**DELEGATED DECISION FOR APPLICATION FOR CERTIFICATE OF LAWFUL
DEVELOPMENT**

Reference no.: 2024/CL/93442/E

Site: 20A, Quarryfields, Mirfield, WF14 0NT

Description: Certificate of lawfulness for proposed hip to gable
enlargement and rear dormer extension

Drawing Title
 PROPOSED

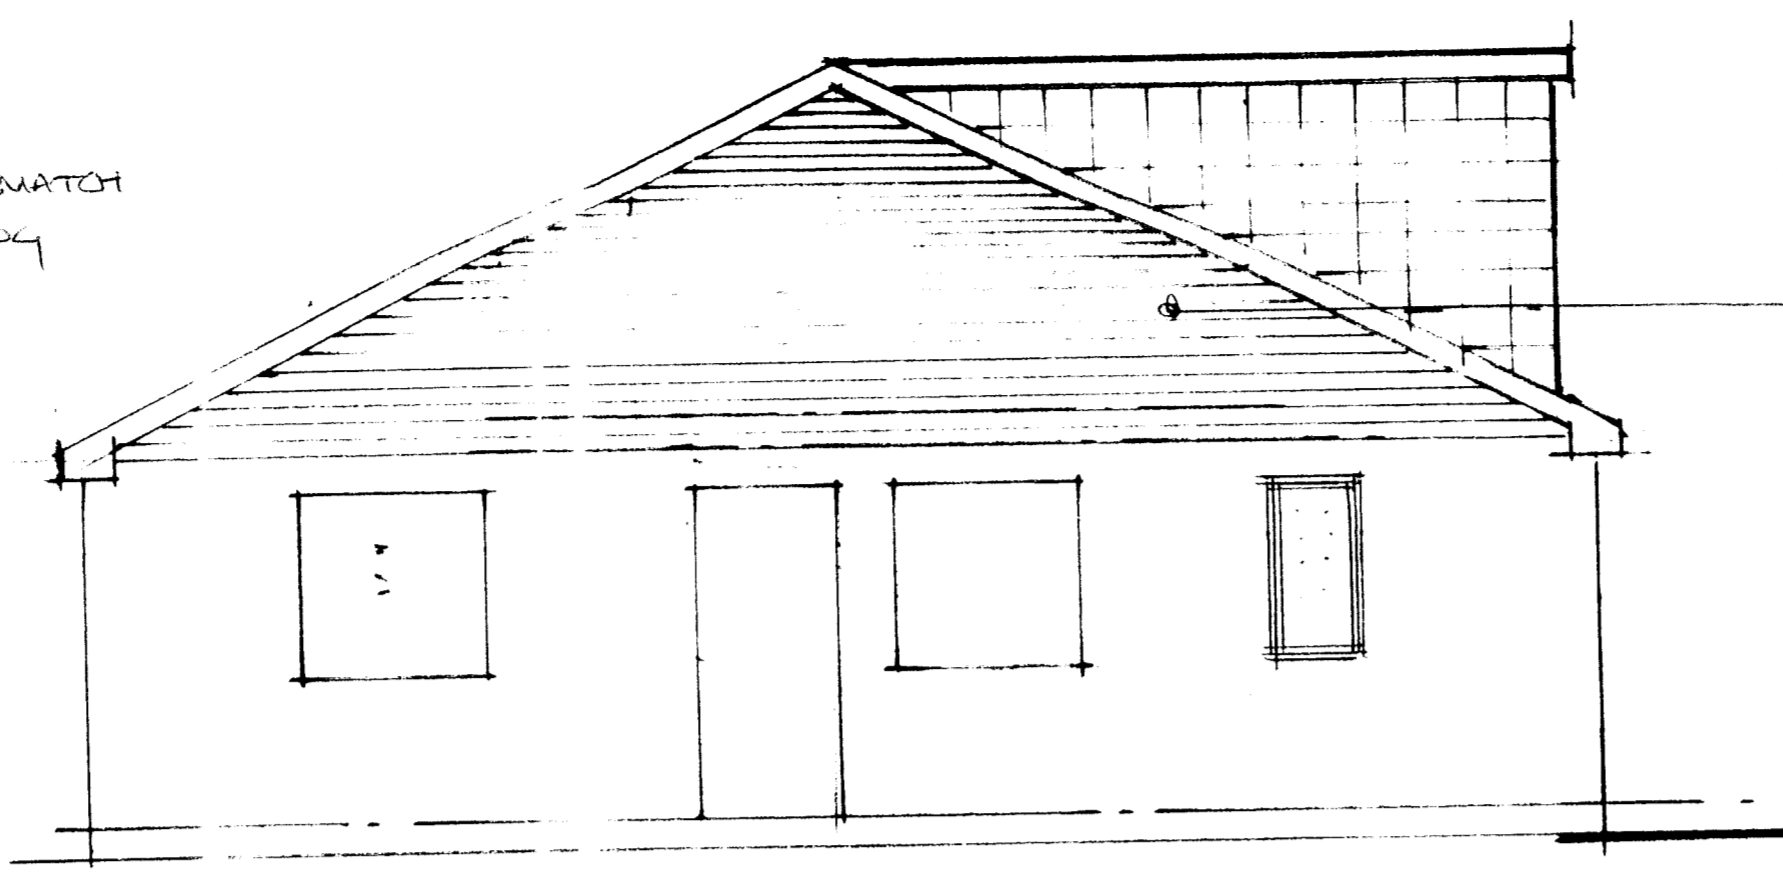
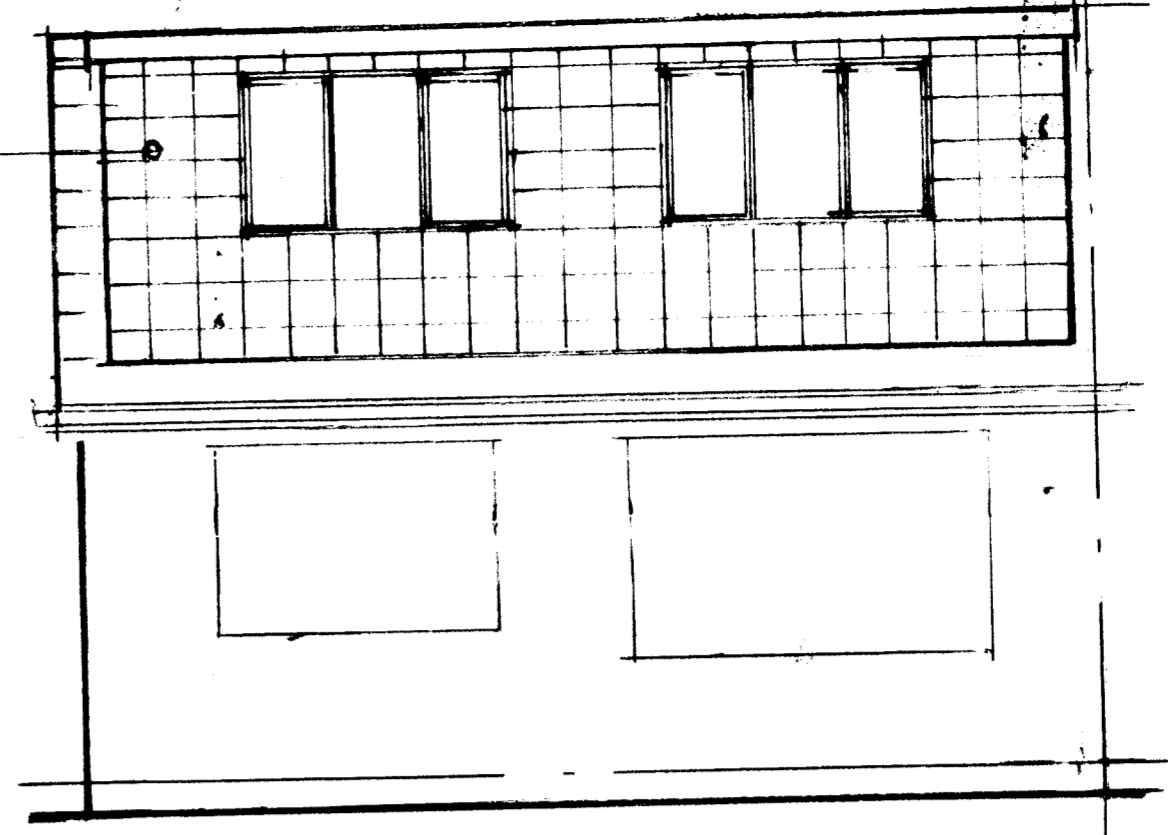
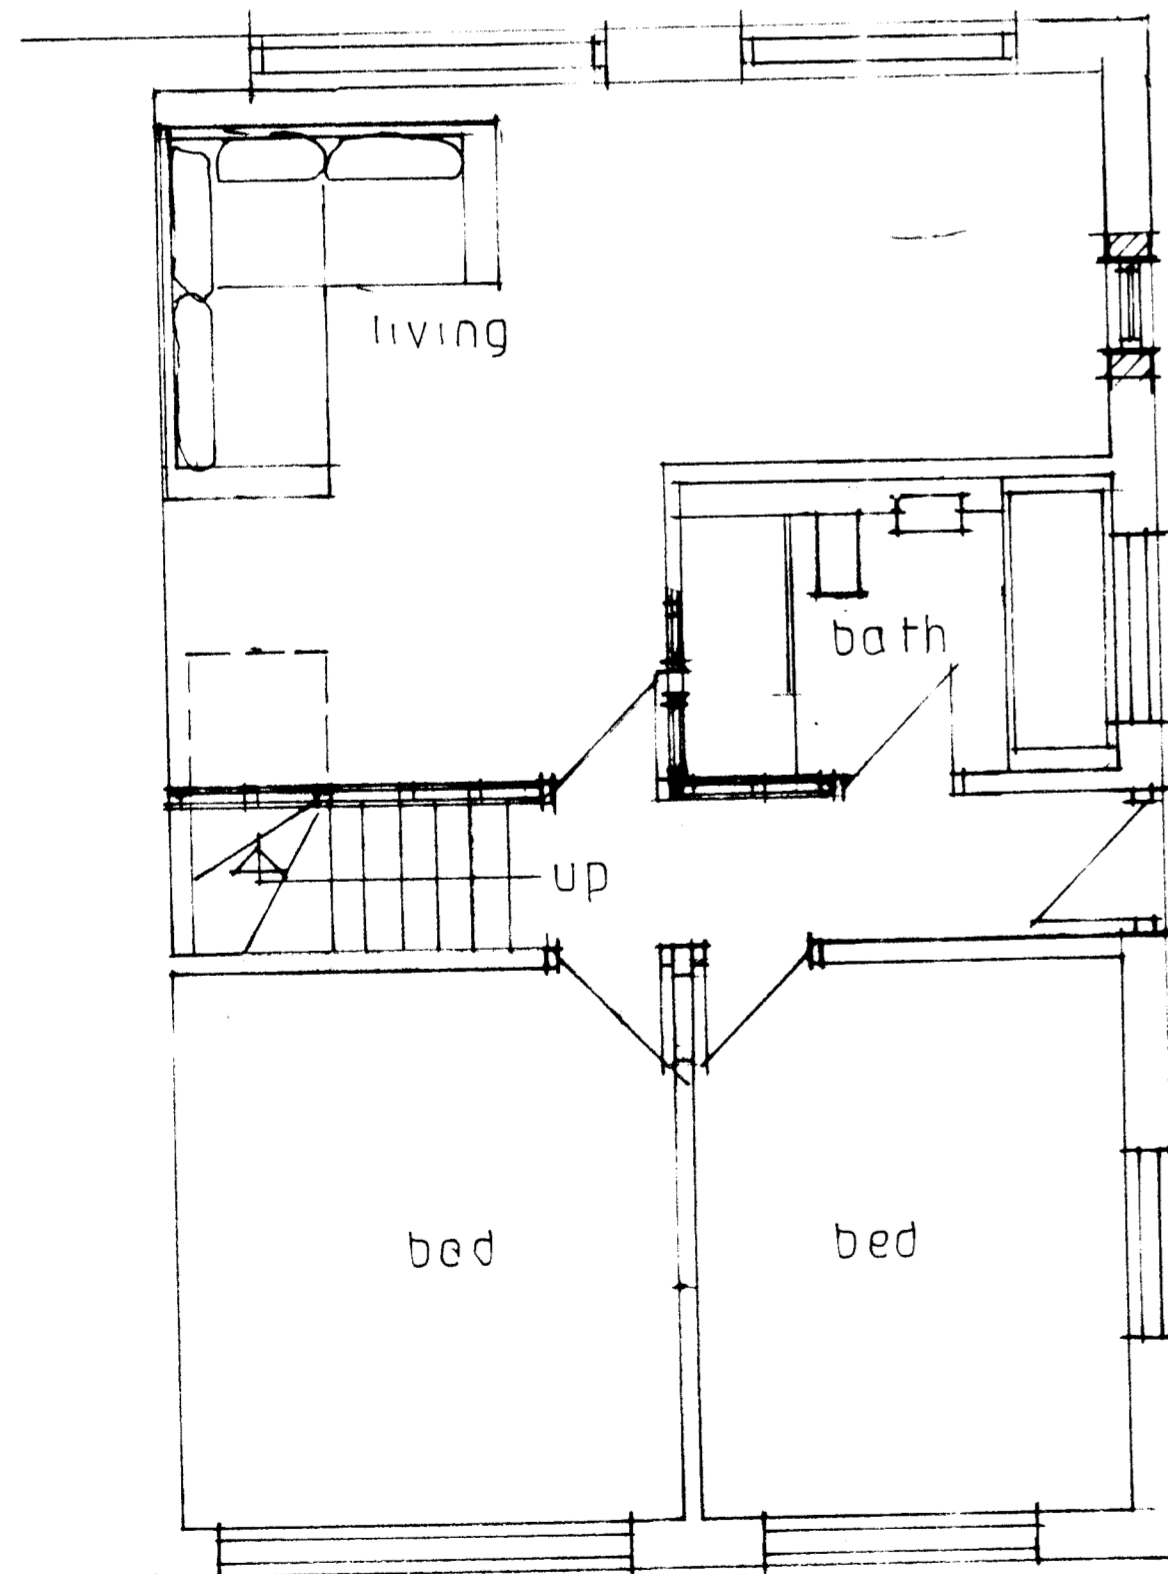
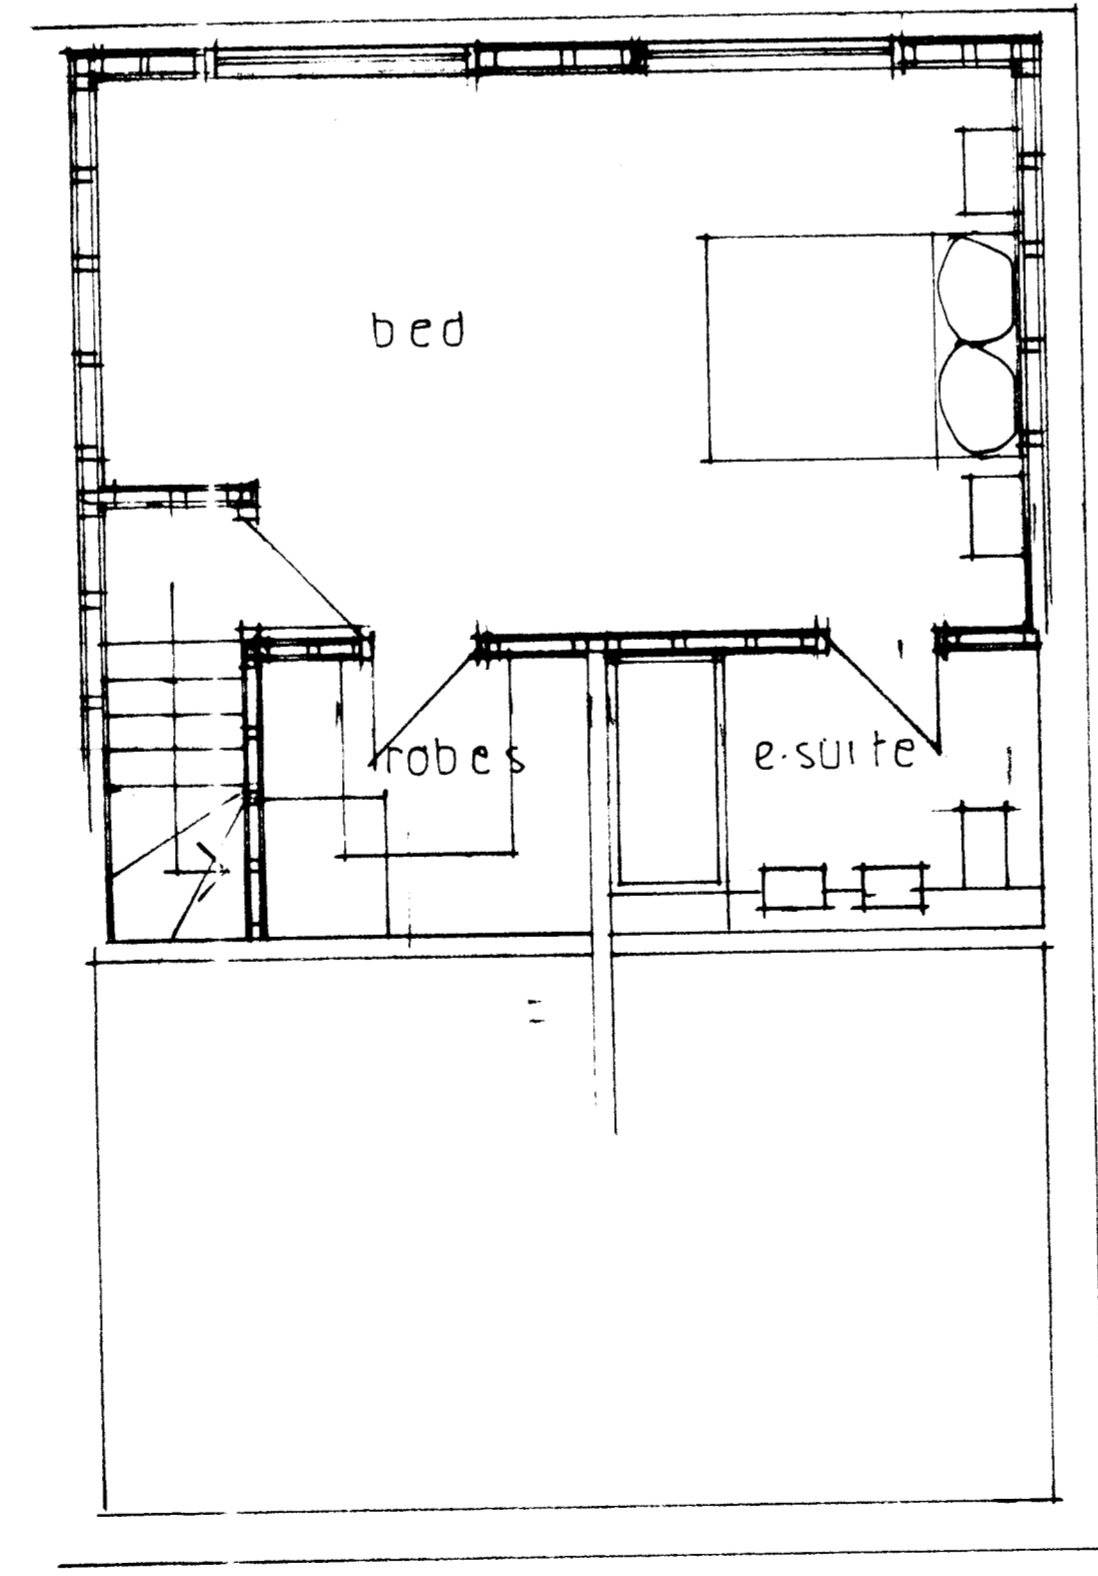
Comment: *As a semi-detached property, the maximum additional roof volume permitted is 50 cubic metres. The proposed dormer enlargement measures, 2.3m high x 4.6 m deep x 6.3m long with a cubic content*

of 33.3 cub. Metres. The hip to gable enlargement measures, 5.1m ridge to gable x 10m long x 2.5m high with a cubic content of 21.2 cub. metres. The total cubic content of the enlargements is 54.5 cubic metres. The cubic content of the dormer and hip-to-gable extension would therefore exceed 50 cubic metres.

The proposed dormer extension and hip-to-gable roof enlargement do not benefit from general planning permission granted by virtue of Article 3(1) and Schedule 2, Part 1 Class B of the Town and Country Planning (General Permitted Development) (England) Order 2015 (as amended) as the total enlargement exceeds 50 cubic metres contrary to sub-paragraph B.1(d).
